Our ref: Q230249
Your ref: 20/04145/FU
Email: sean.rawling@quod.com
Date: 22 November 2023

Town and Country Planning Act 1980 (as amended)
Section 96a and Section 73 Applications Pursuant to Planning Permission
Reference 20/04145/FU
Foundry Street / Saxton Lane Former, Leeds

Please find enclosed a Section 96a (S96a) and Section 73 (S73) application on behalf of Wakefield and District Housing Ltd (the “Applicant”) pursuant to planning permission 20/04145/FU (the “Consent”) at Foundry Street / Saxton Lane, Leeds (the “Site”).

- **Section 96a:** seeks non-materials amendments to the elevations and an extension of the stair core at from levels 17 to 19.
- **Section 73:** seeks consent for an additional three affordable units in place of the first floor amenity space.

TWO STAIR CORE PLANS
SAXTON HOUSE, LEEDS
PROPOSED SITE PLAN

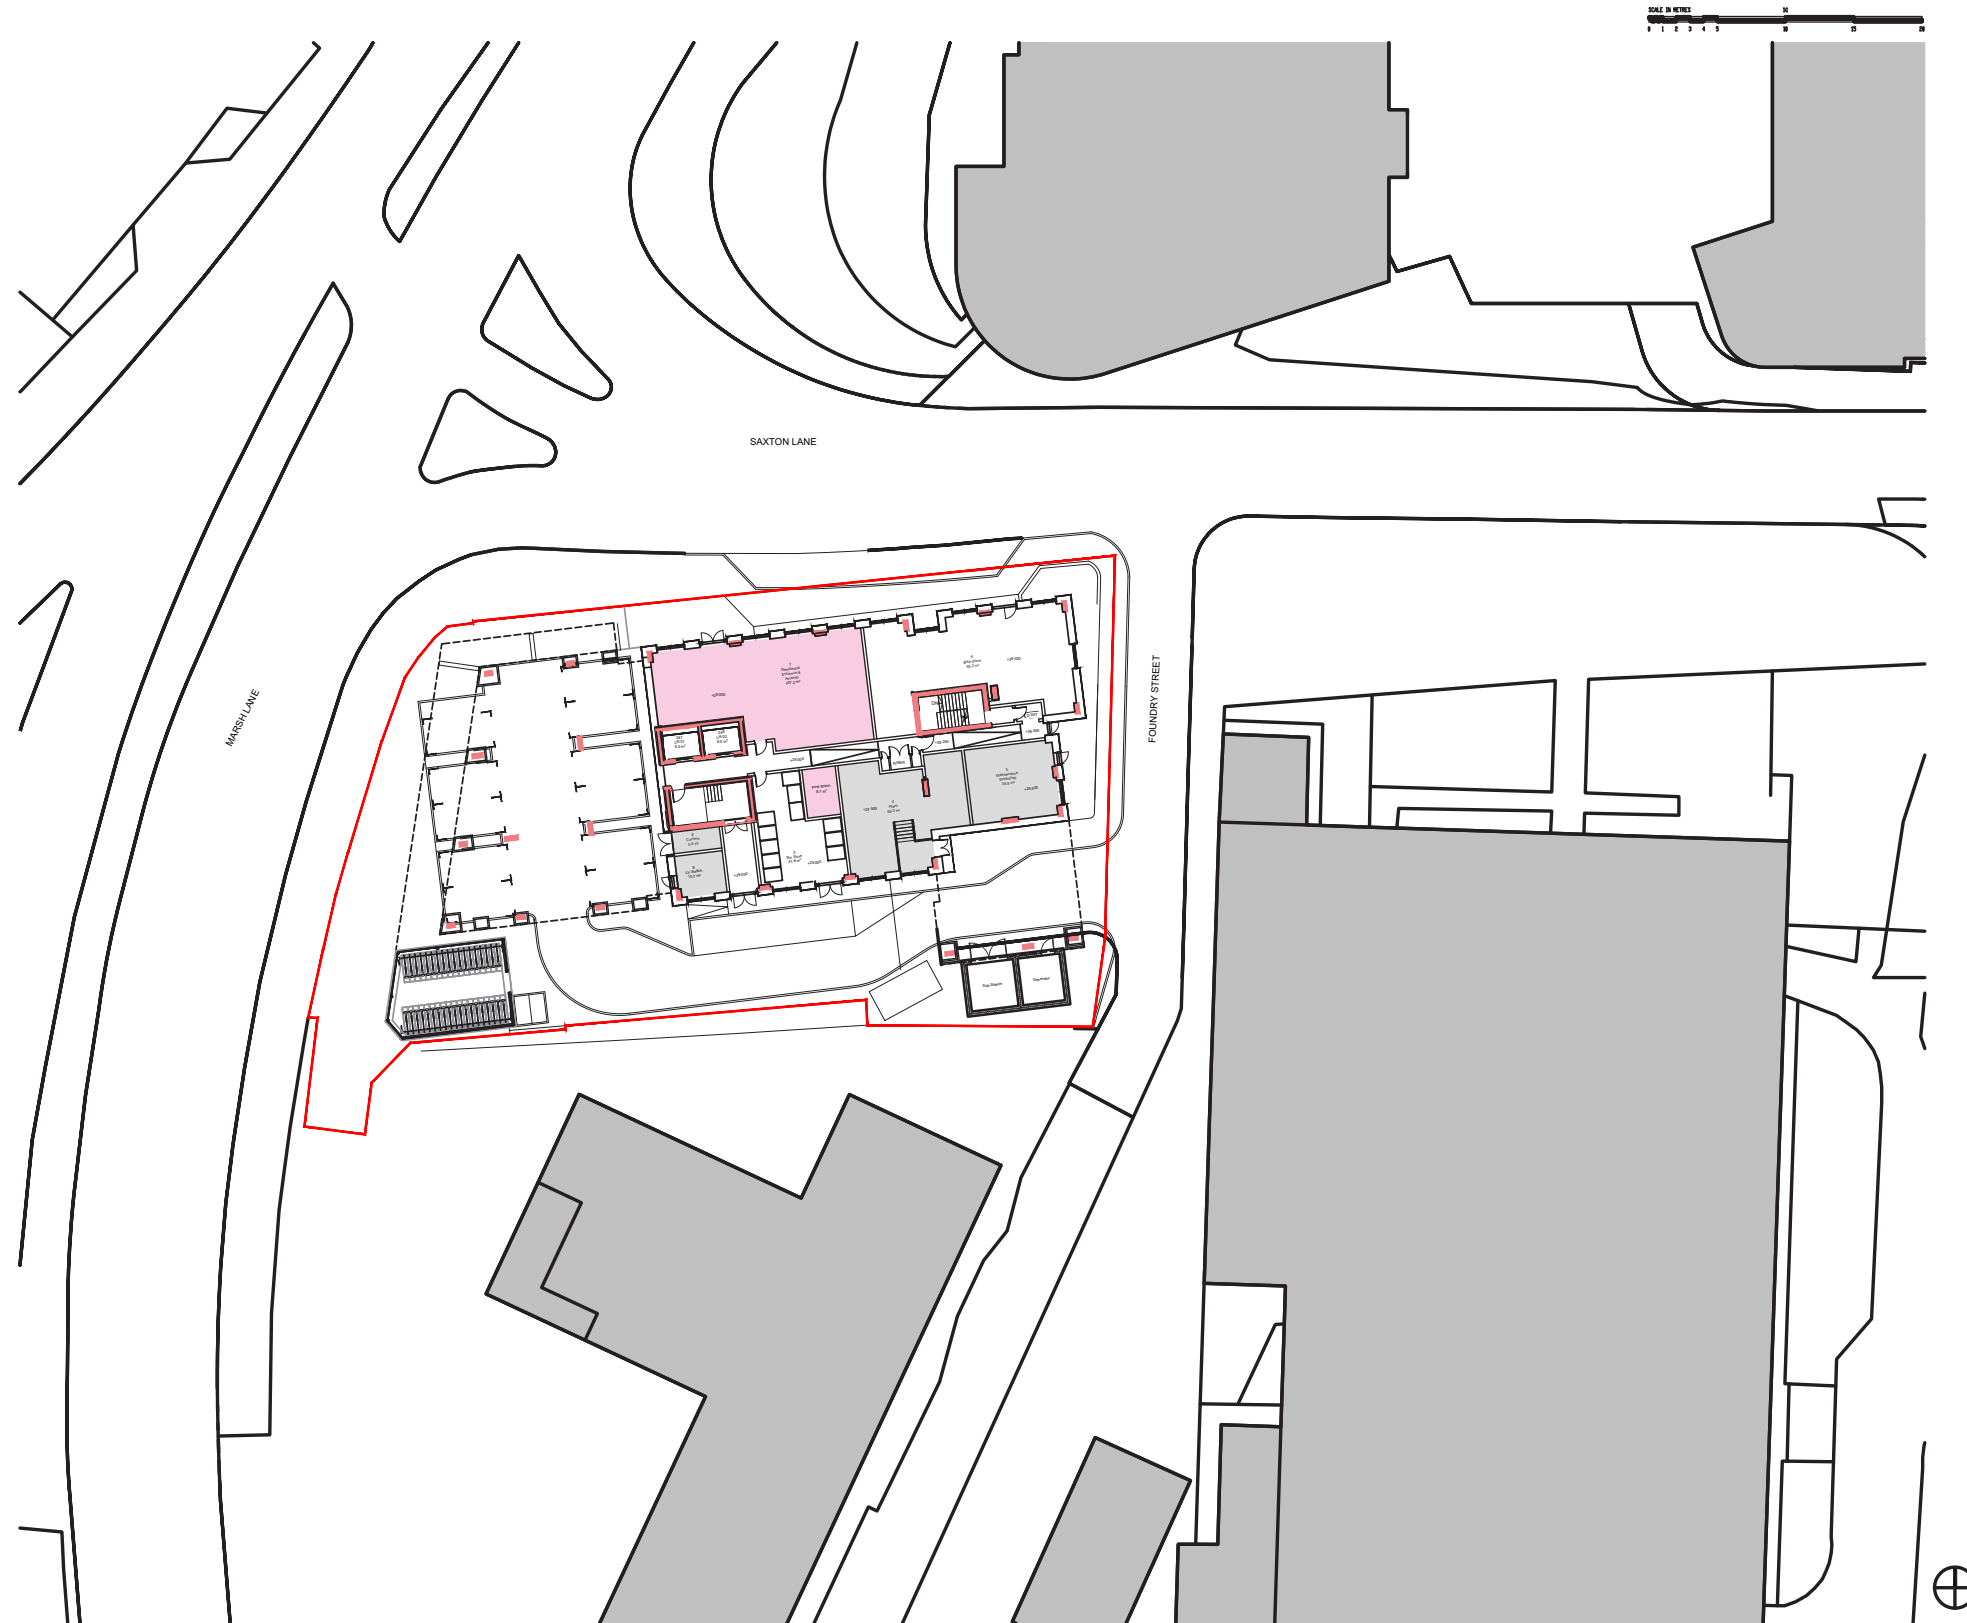
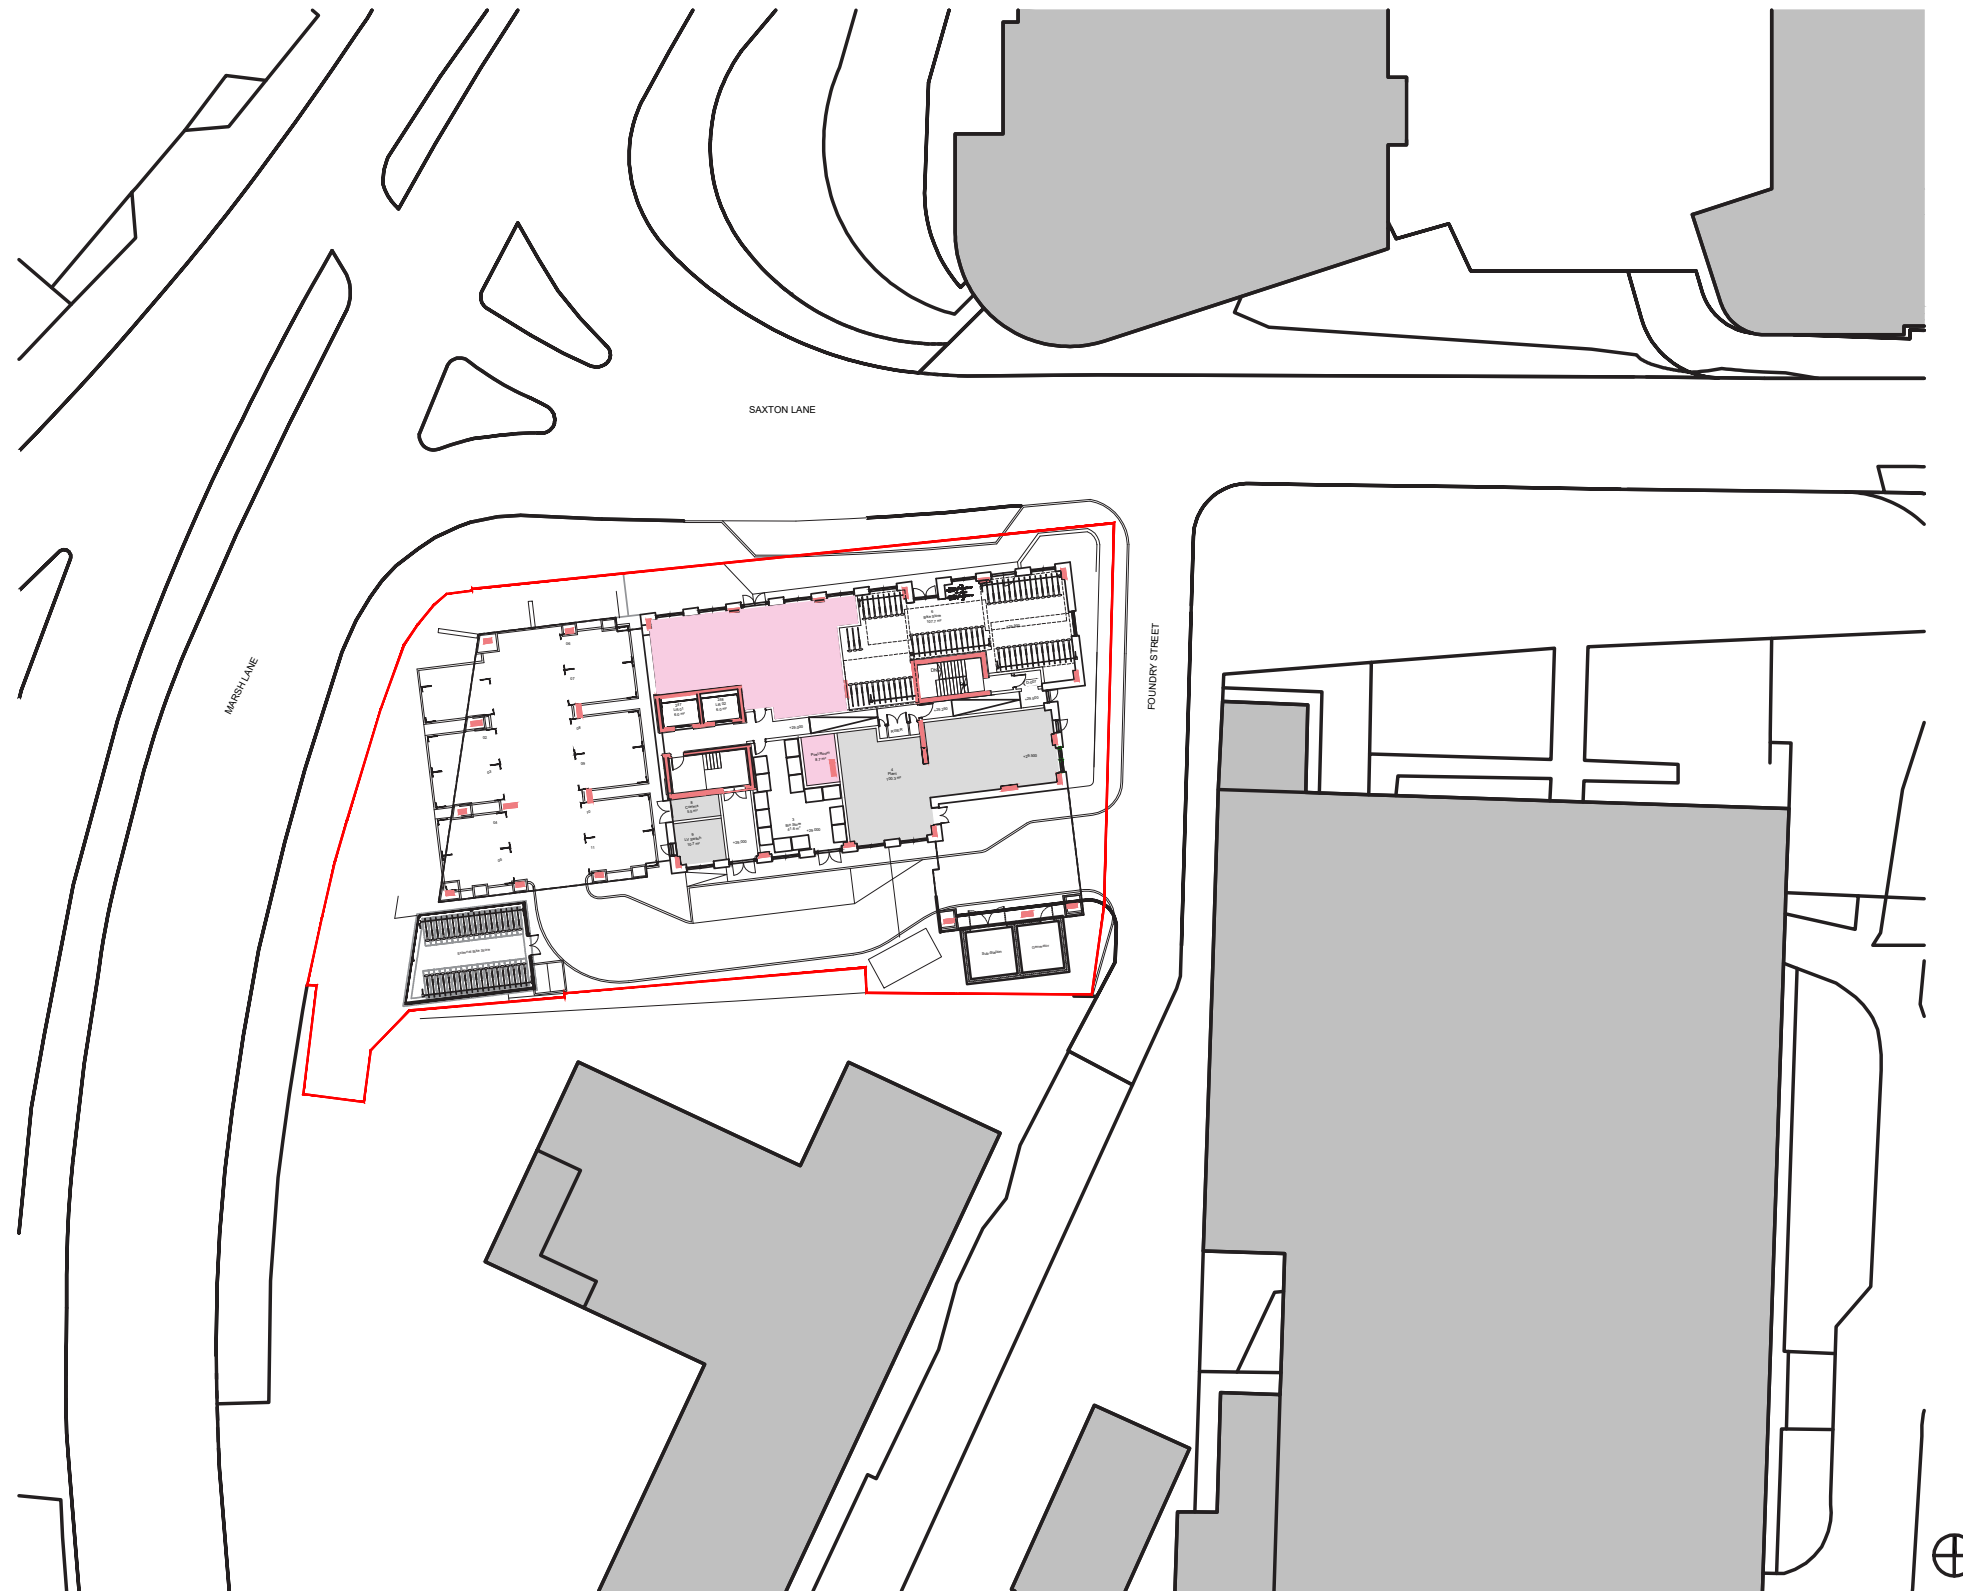
- Shift of proposed entrance.
- Extension of bike store to allow for 207 spaces.
- Additional fire escape door along eastern elevation for second stair core.
- Shift of windows between living space and bedroom to allow for wider window to living spaces at levels 2 to 19, along central spine of the northern and southern elevations.

The amendments seek a slight extension to the bike store, to provide 207 cycle parking spaces. There are no other changes to the cycle / car parking, and this remains compliant with the Transport SPD.
